## Application for a Non-Material Amendment Following a Grant of Planning Permission

Submission of Details (Reserved Matters) for Outline Planning Permission DC/21/02648 - Appearance, Landscaping, Layout and Scale to be considered for 1no dwelling

DC/23/01432

Cream weatherboarding to porch and projecting dormer roofs  
Amendments to internal room layout and related fenestration.

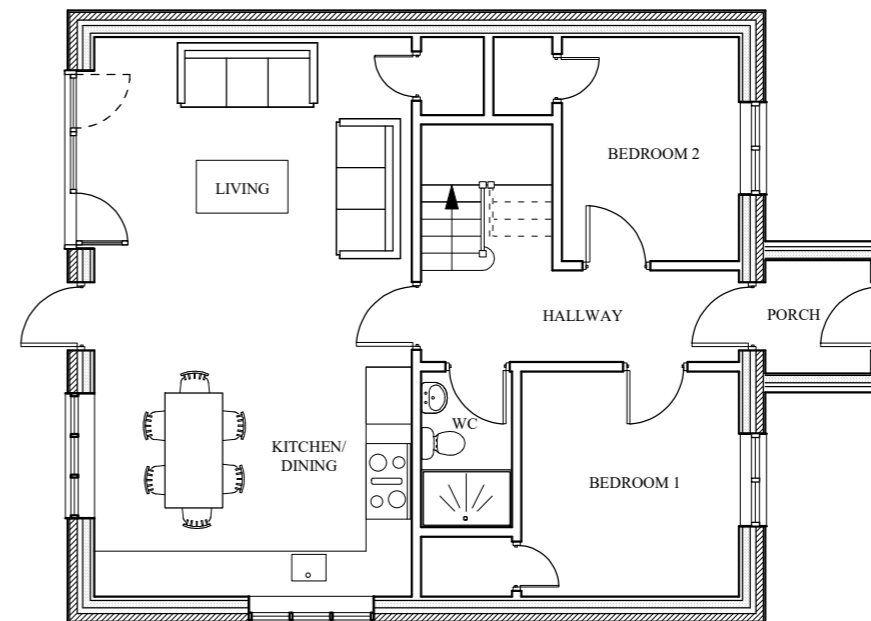
Provide variation in materials to suit the timber construction of porch and dormers.  
Internal room layout and related fenestration amended to better suit the owner/self builders requirements

Proposed Floor Plans - NMA 02  
Proposed Elevations - NMA03
